From: Holmstrom, Rick [HolmstR@wsdot.wa.gov]
Sent: Thursday, January 28, 2010 9:03 AM
To: Jeff Watson
Cc: Preston, Bill; Eberle, Dan; Kukes, Terry
Subject: RE: SP-09-00008 Hedrick
Attachments: SP-09-00008 Hedrick Master File.pdf

SP-09-00008 Hedrick

TO: Community Development Services
FROM: Christina Wollman, Planner II *CW*
DATE: May 15, 2009
SUBJECT: Hedrick 2 Short Plat SP-09-00008

RE: Hedrick Short Plat SP-09-00008

HEDRICK 2 SHORT PLAT

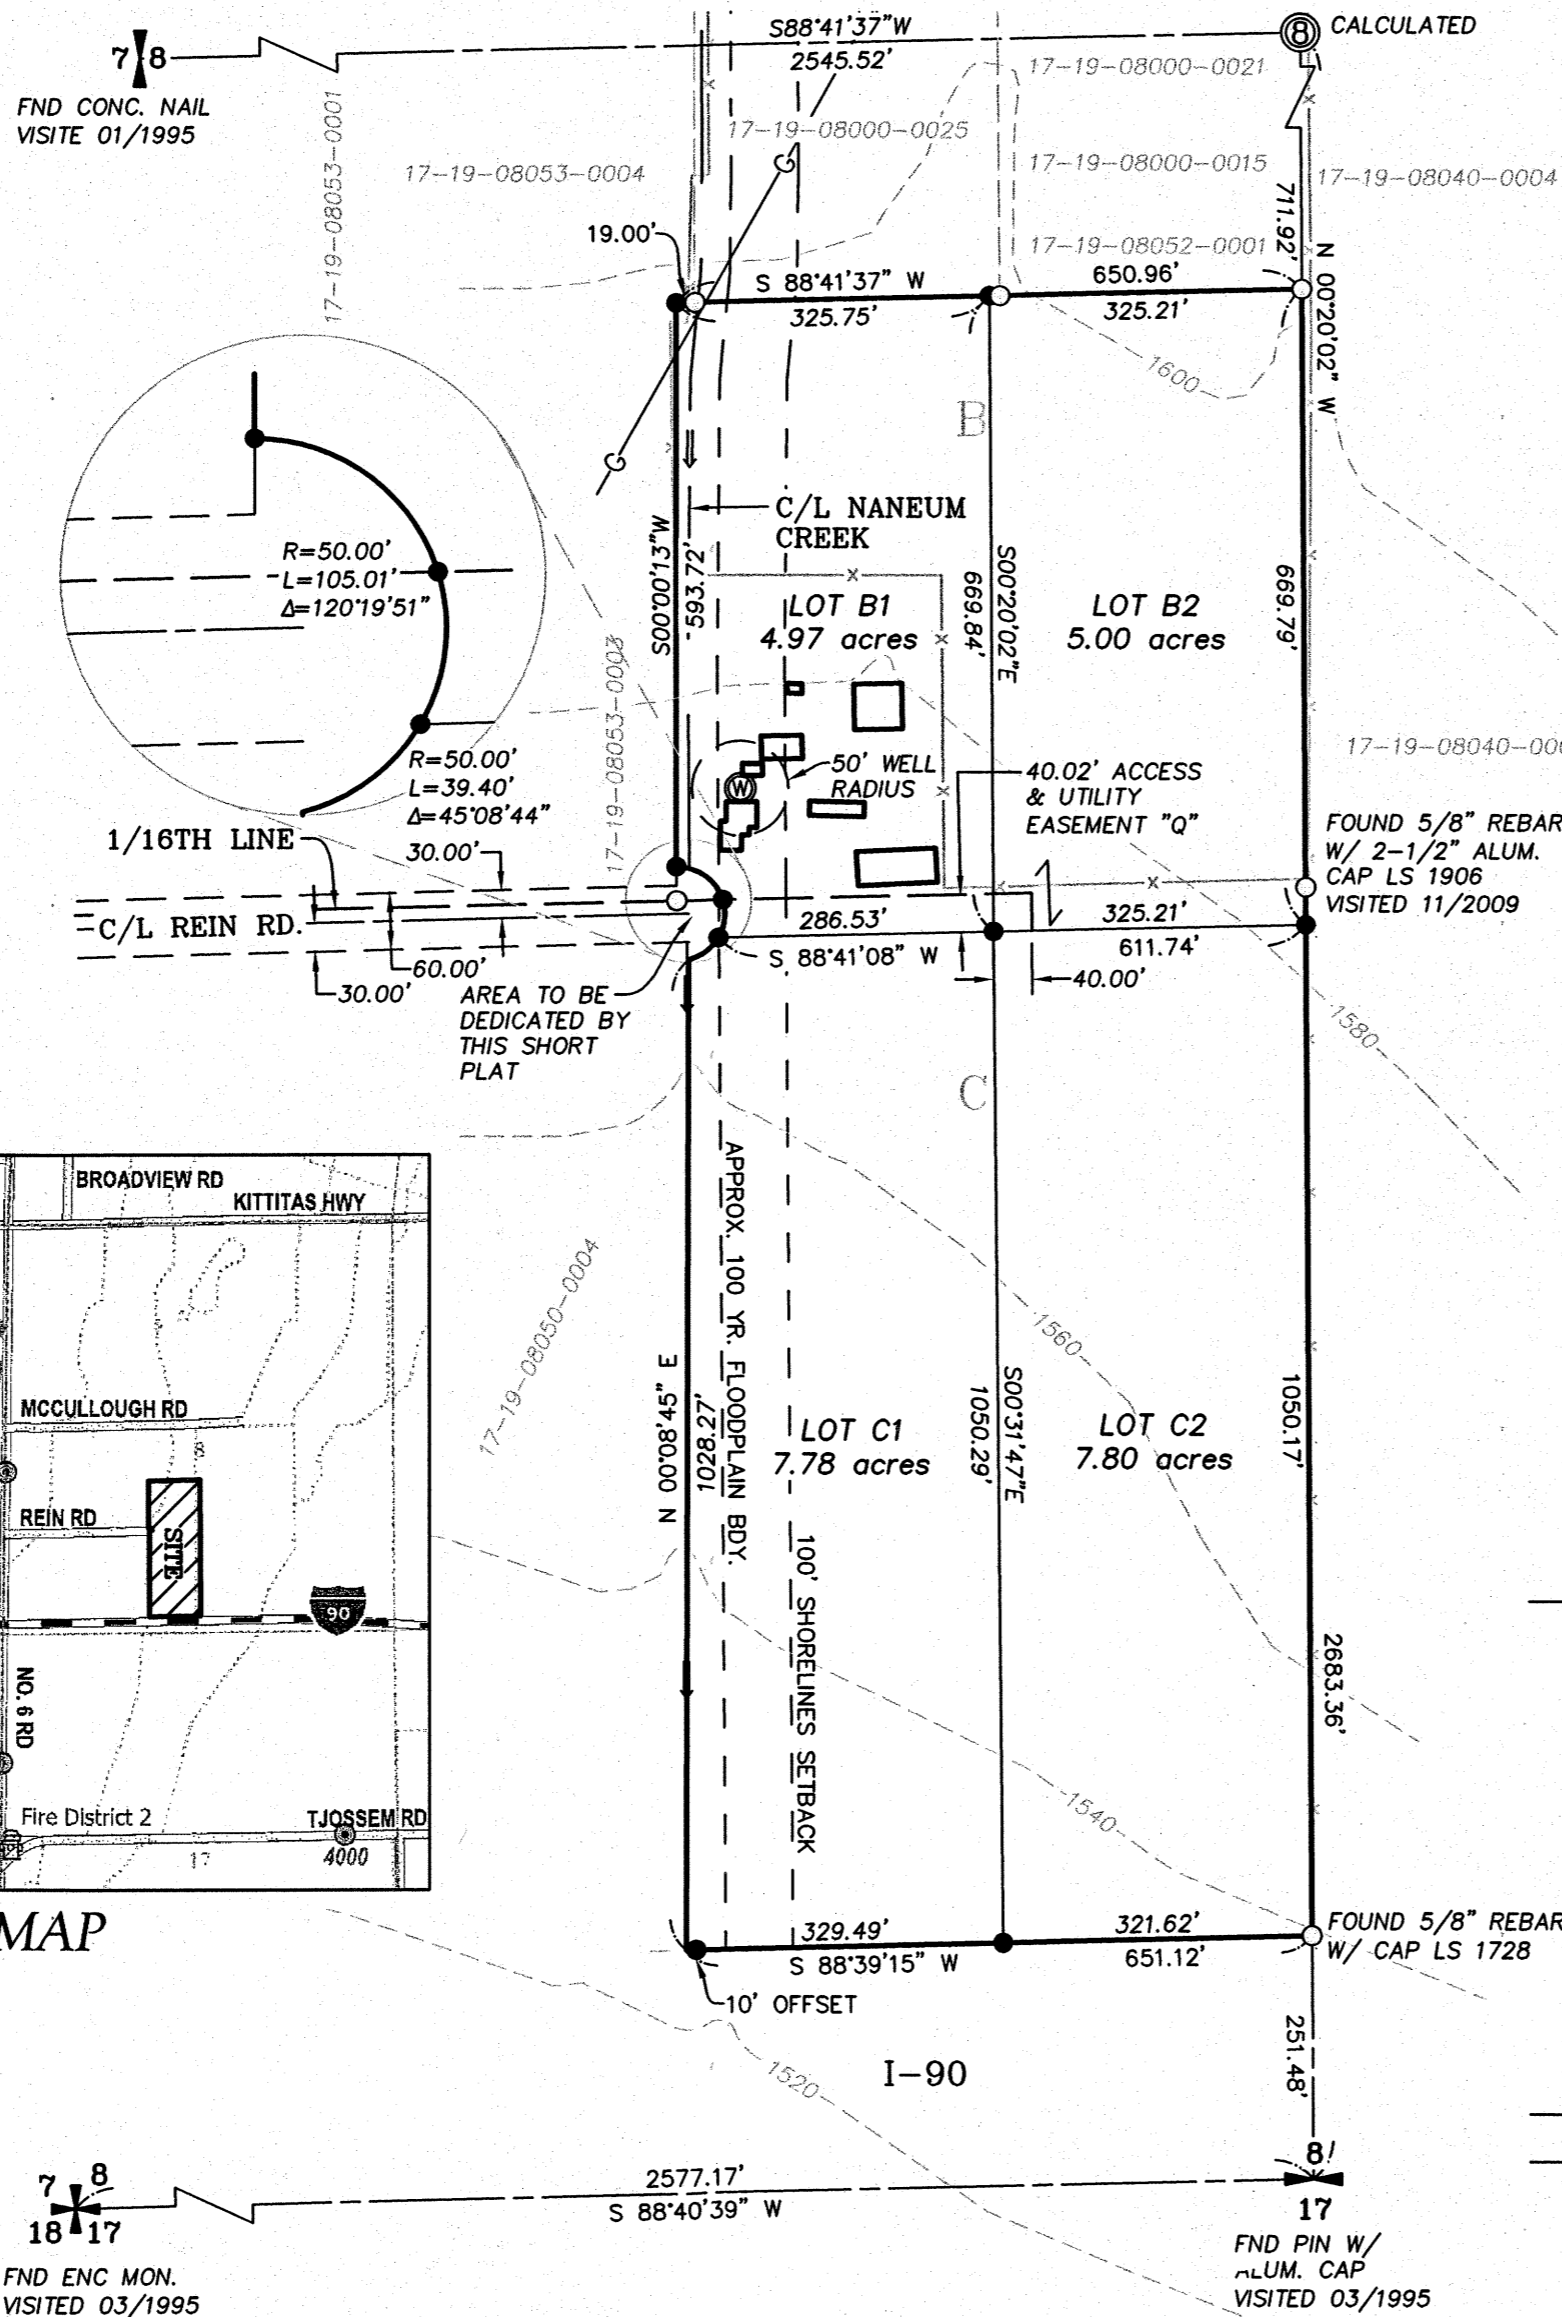
1. Cul-de-Sac Dedication: To help complete the cul-de-sac right of way at the end of Rein Road, the portion of cul-de-sac right-of-way lying within Lot B1 and/or C1 shall be dedicated to the County. The cul-de-sac portion shall be of equivalent dimension as the portion dedicated during the 1995 short plat.
2. Joint-Use Driveway: A joint-use access shall serve no more than two tax parcels. See Kittitas County Road Standards, 9/6/05 edition.
 - a. Access easements shall be a minimum of 20' wide. The roadway width shall have a minimum width of 12'.
 - b. The surface requirement is for a minimum gravel surface depth of 6”.
 - c. Maintenance of driveway approaches shall be the responsibility of the owner whose property they serve. The County will not maintain accesses.
 - d. Any further subdivision or lots to be served by proposed access may result in further access requirements.

Single-Use Driveway: A single-use access shall serve no more than one lot. See Kittitas County Road Standards, 9/6/05 edition.

- a. The roadway shall be a minimum of 8' wide with gravel surface.

- b. Maintenance of driveway approaches shall be the responsibility of the owner whose property they serve. The County will not maintain accesses.
- c. Any further subdivision or lots to be served by proposed access may result in further access requirements.
